Drayton South Coal Project:

Response to the Environmental Impact Statement and the Secretary's Environmental Assessment Report Scenic and Visual Impacts

October 2015

COOLMORE AUSTRALIA & DARLEY AUSTRALIA

Figure 2C: Year 4 Mine Plan – Drayton South

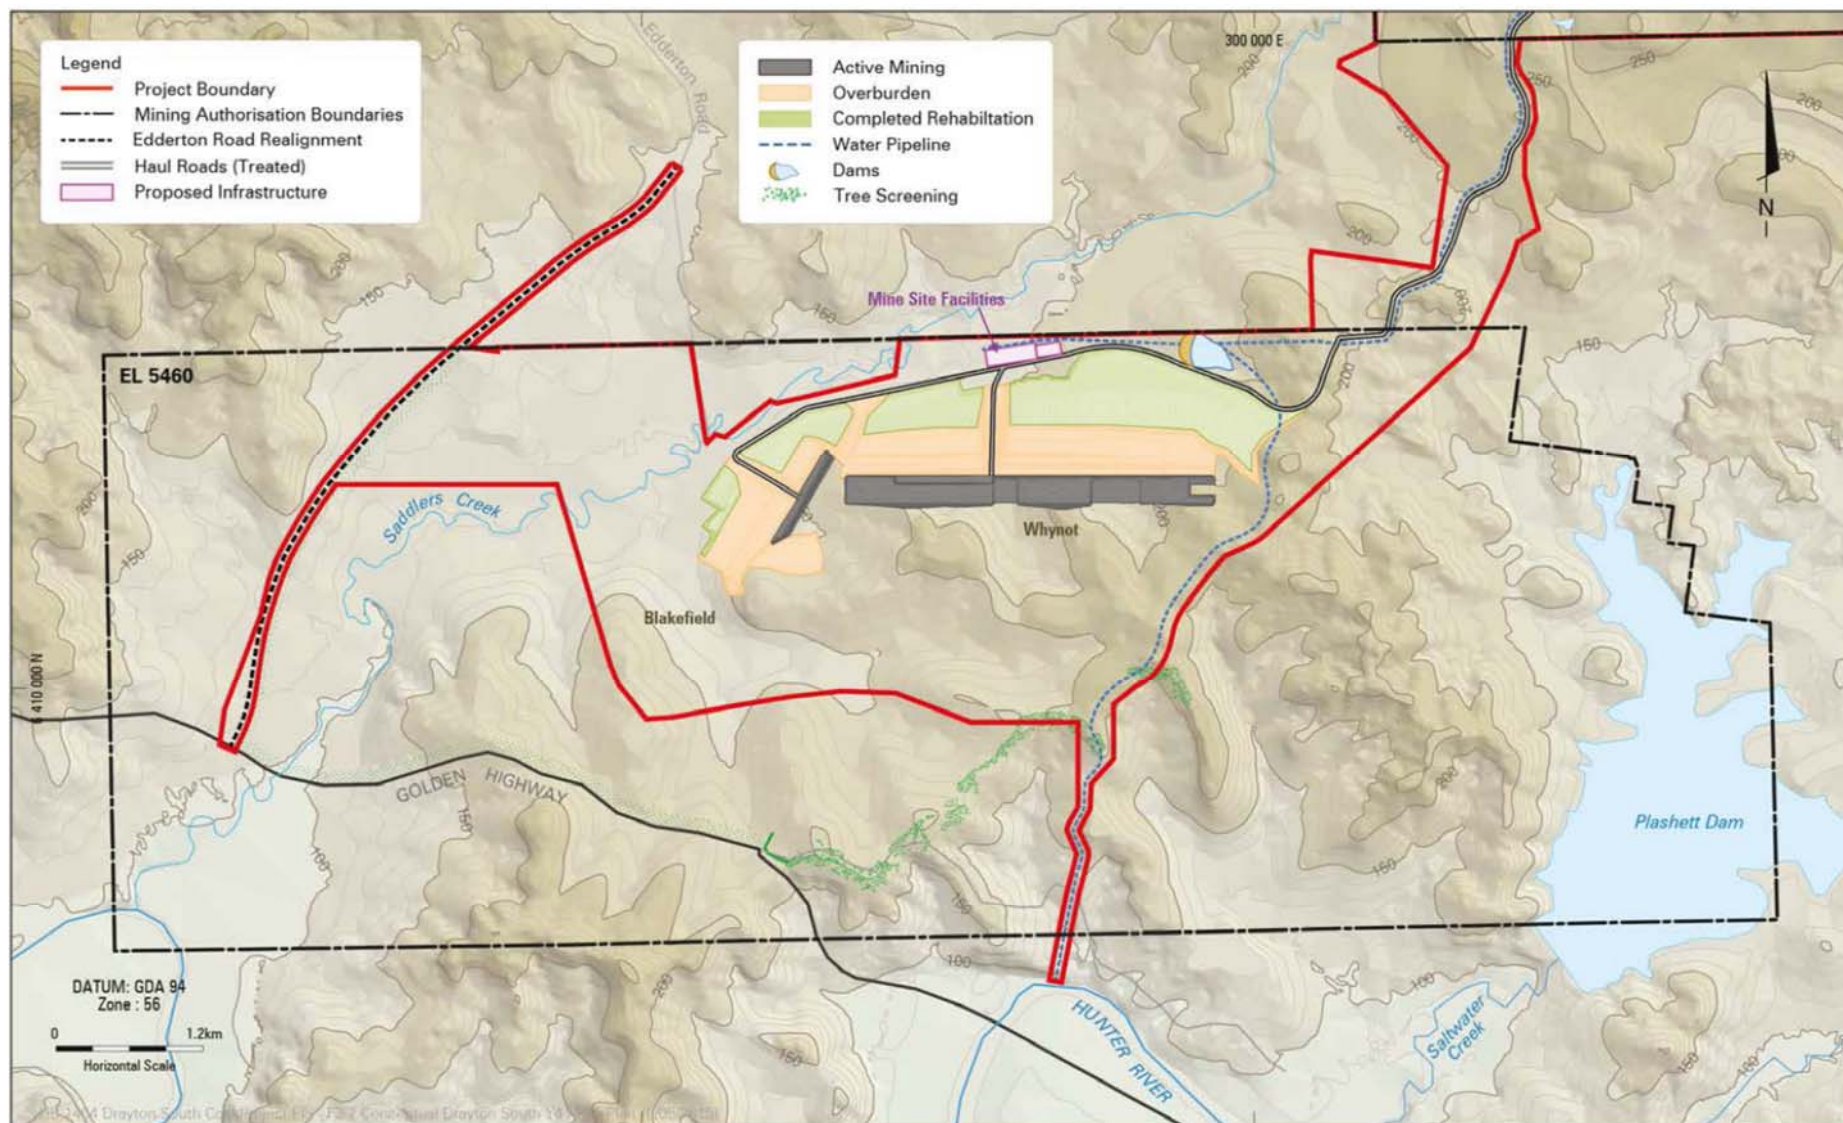
Edderton Road is to remain in use until Year 4 of the mine's operation and the plan in the top right of Figure 9 (page 16) shows that the mine workings will be immediately adjacent to

this public road. However no screening of the mine workings are proposed for this road in the EIS.

Edderton Road will remain open to the public for the first 4 years of the mine life and would appear to have no screening proposed along the eastern boundary with the proposed mine. The elevated lands on both Coolmore and Woodlands cannot be protected from the visual impacts of the mine due to their elevation and open landscape character. As such, these areas will remain impacted for the full life of the mine.
